West Burton Solar Project

Draft Statement of Common Ground with Environment Agency

April 2024

Document reference: ~~EX1~~EX5/WB8.3.5_A

General Legend:	
	Order Limits
	Fence
	Potential Development Area
	Mounting Structures and Solar PV Modules
	Conversion Units
	Electrical Substation
	High Voltage Electricity Cable
	Maintenance Tracks
	Gates
	Site Access
	CCTV
	River Till Flood Storage Area

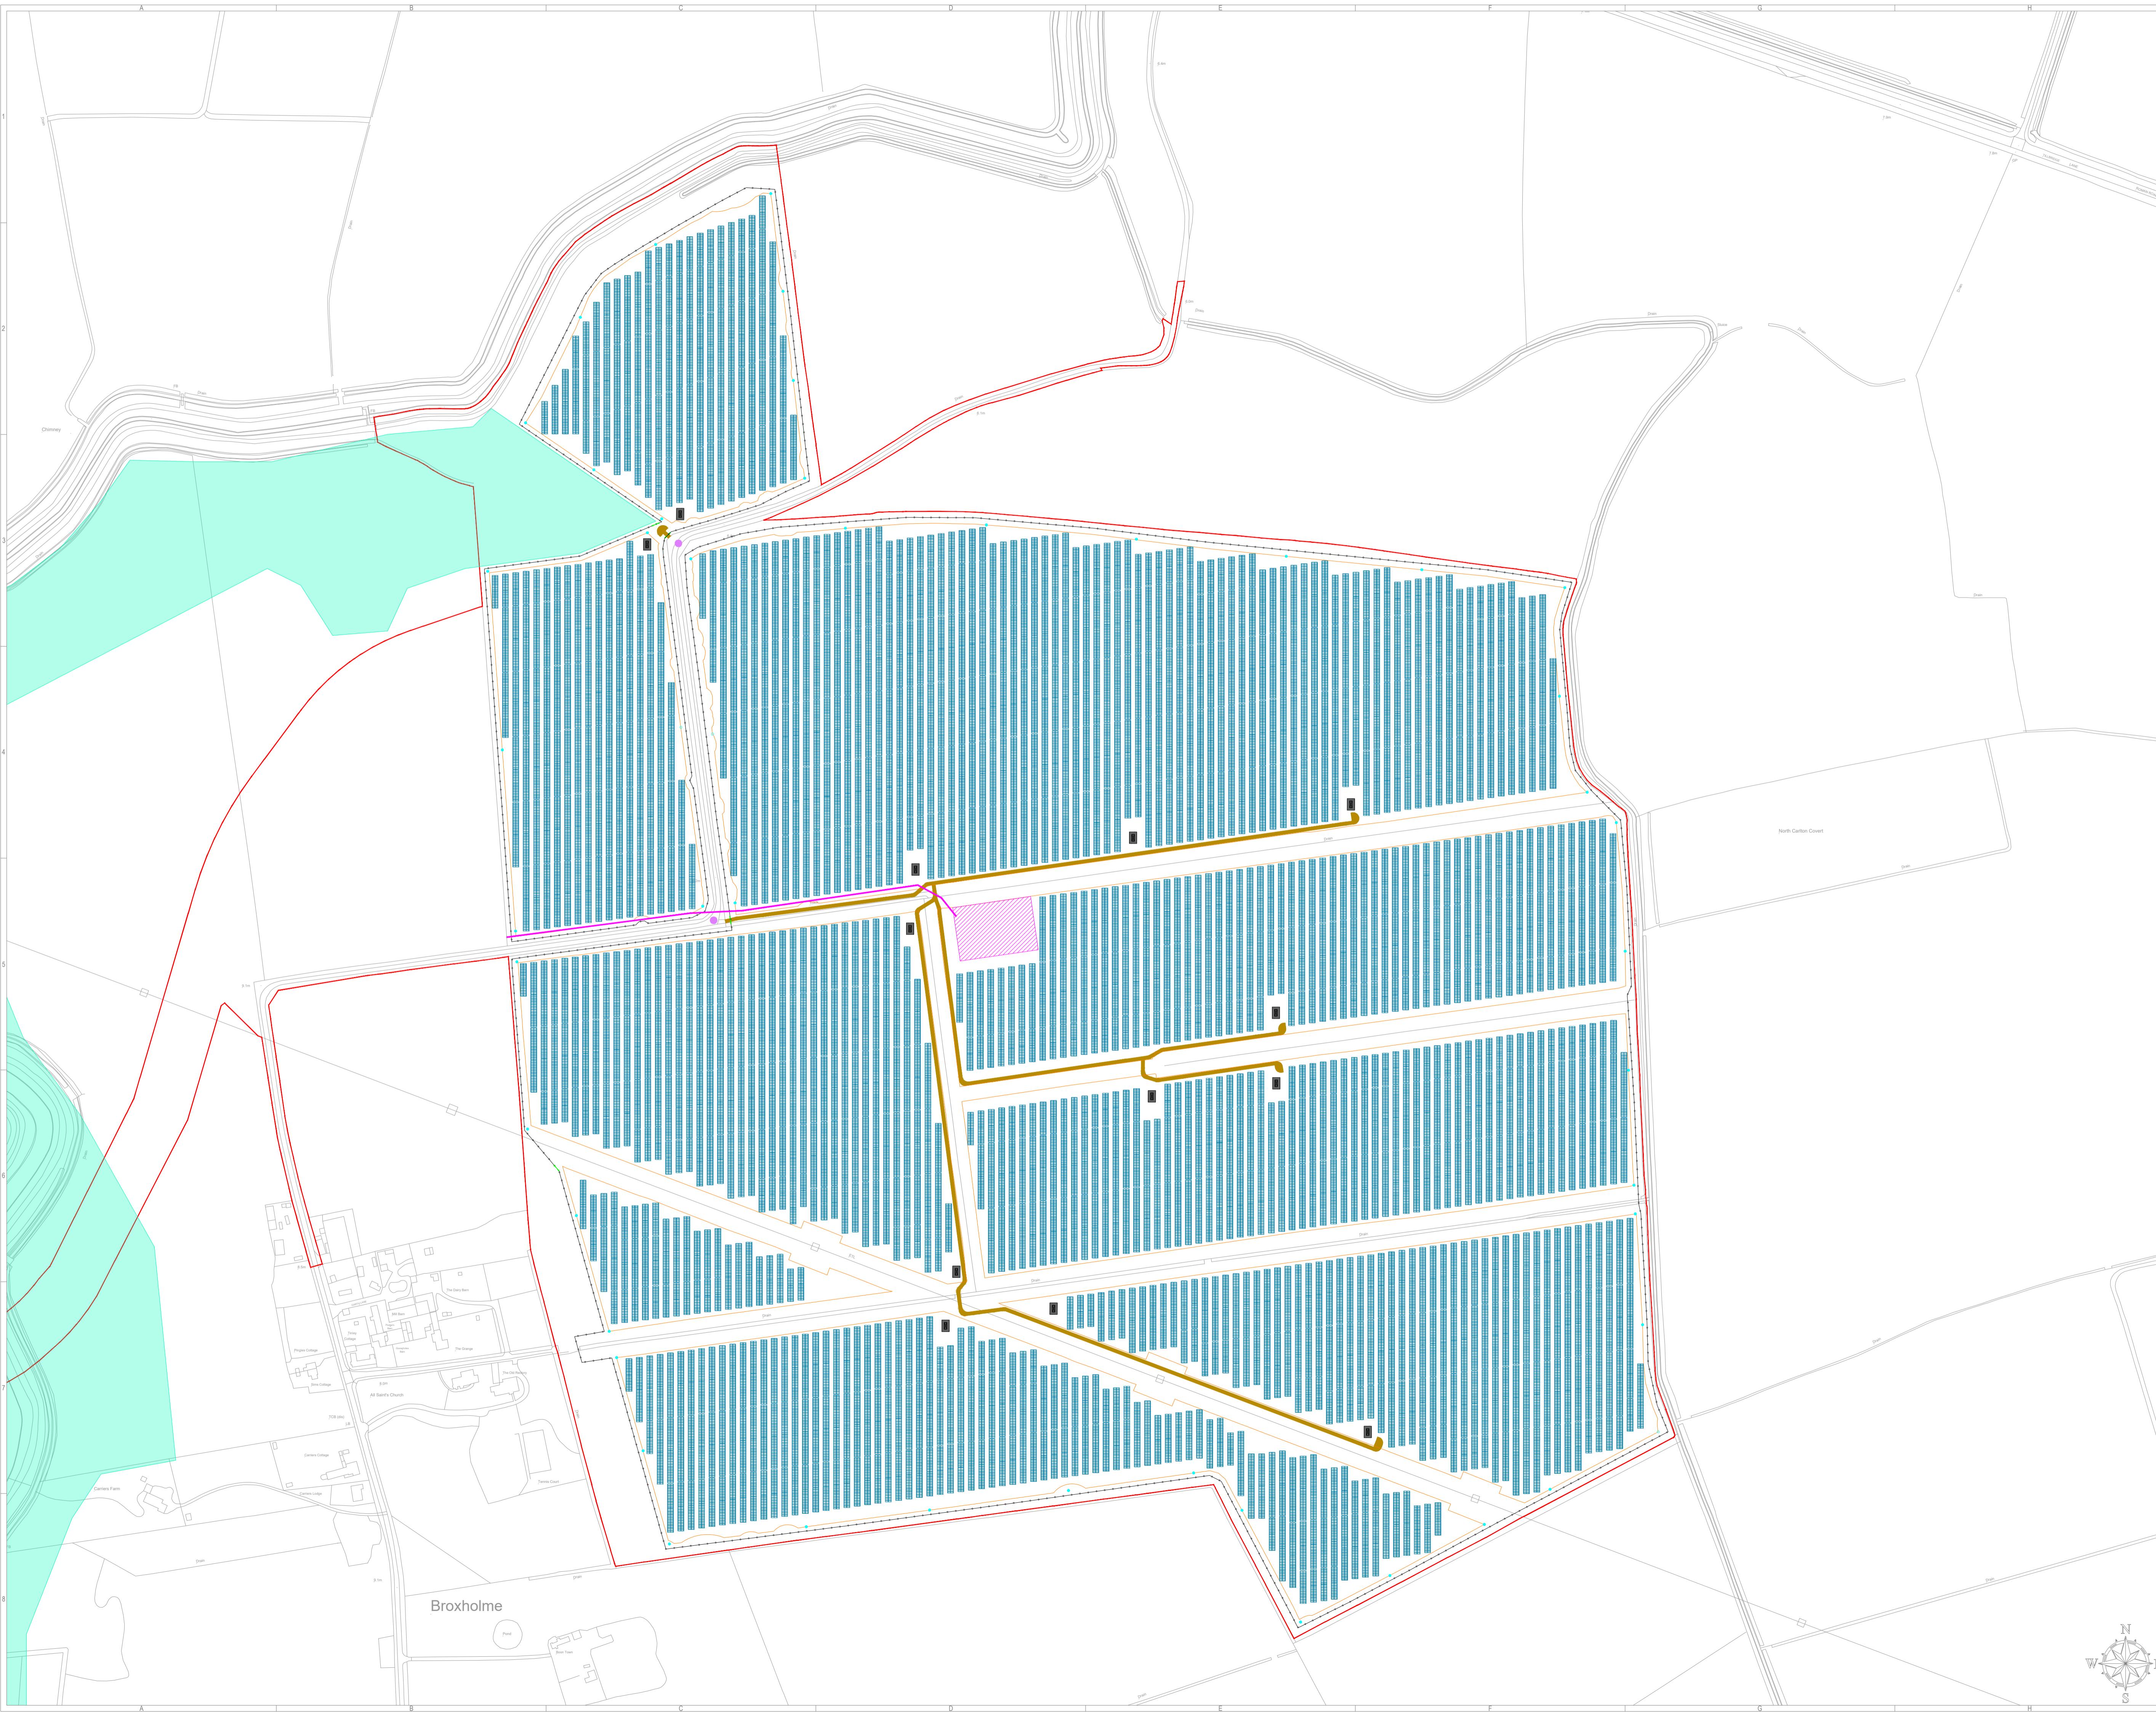
<p>Understand that no development will be situated within the River Till Flood Storage Area (FSA) and that the FSA should be included within the illustrative site layout plan 6.3.10.5 Environmental Statement - Appendix 10.5 FRA DS West Burton 3 [APP-093].</p> <p>They welcome the use of trenchless excavation techniques for river crossings in accordance with the methodology within FRA3.</p> <p>Note that the scheme has been designed so that in the event of a 0.1% Annual Exceedance Probability (AEP) + 20% Climate Change flood event the scheme can electrically isolate and replace damaged infrastructure during a 0.1% AEP + 20% Climate Change flood event without affecting the rest of the scheme. The Secretary of State will determine if this is acceptable for essential infrastructure and the National Policy Statement's requirement for new energy infrastructure to remain operational during floods.</p> <p>Welcome the embedded mitigation to be adopted within the scheme design as outlined in 6.2.10 Environmental Statement - Chapter 10_Hydrology Flood Risk and Drainage [APP-048].</p> <p>Request that although negligible, the cumulative loss of floodplain volume from the posts supporting the photovoltaic panels in Flood Zone 3 should be calculated and an assessment of whether this loss needs to be reasonably compensated for as part of the proposals.</p> <p>The EA will object to any acquisition of land or rights in relation to its land interests until it has had a proper opportunity to assess the potential effects of the acquisitions sought by the applicant on its ability to carry out its operations. However, we will</p>

proposed infrastructure (substations and batteries) and wildflower planting at the leeward edge of solar panels will ensure that the Scheme is unlikely to generate surface water runoff rates beyond the baseline scenario. A Water Management Plan will form part of the detailed CEMP which will manage impacts to water quality from runoff as set out in 7.1_C Outline Construction Environmental Management Plan [APP-309] Revision C [REP4-042] .
HFD-05 Hydrology, Flood Risk and Drainage	Layout	It is understood that no development will be situated within the River Till Flood Storage Area (FSA). For the avoidance of doubt, we would ask that the applicant overlay the River Till FSA outline onto the illustrative site layout plan and include it within Appendix 10.5 of the ES.	The Applicant notes this comment, but understands that Appendix 10.5 of the ES refers to West Burton 3, which does not include any part of the River Till FSA. The Applicant instead understands that the EA is referring to Appendices 10.3 and 10.4 of the ES. A plan overlaying the River Till FSA outline onto the illustrative site layout plan will be produced and was submitted at Deadline 1 . [REP1-022 and REP1-024]
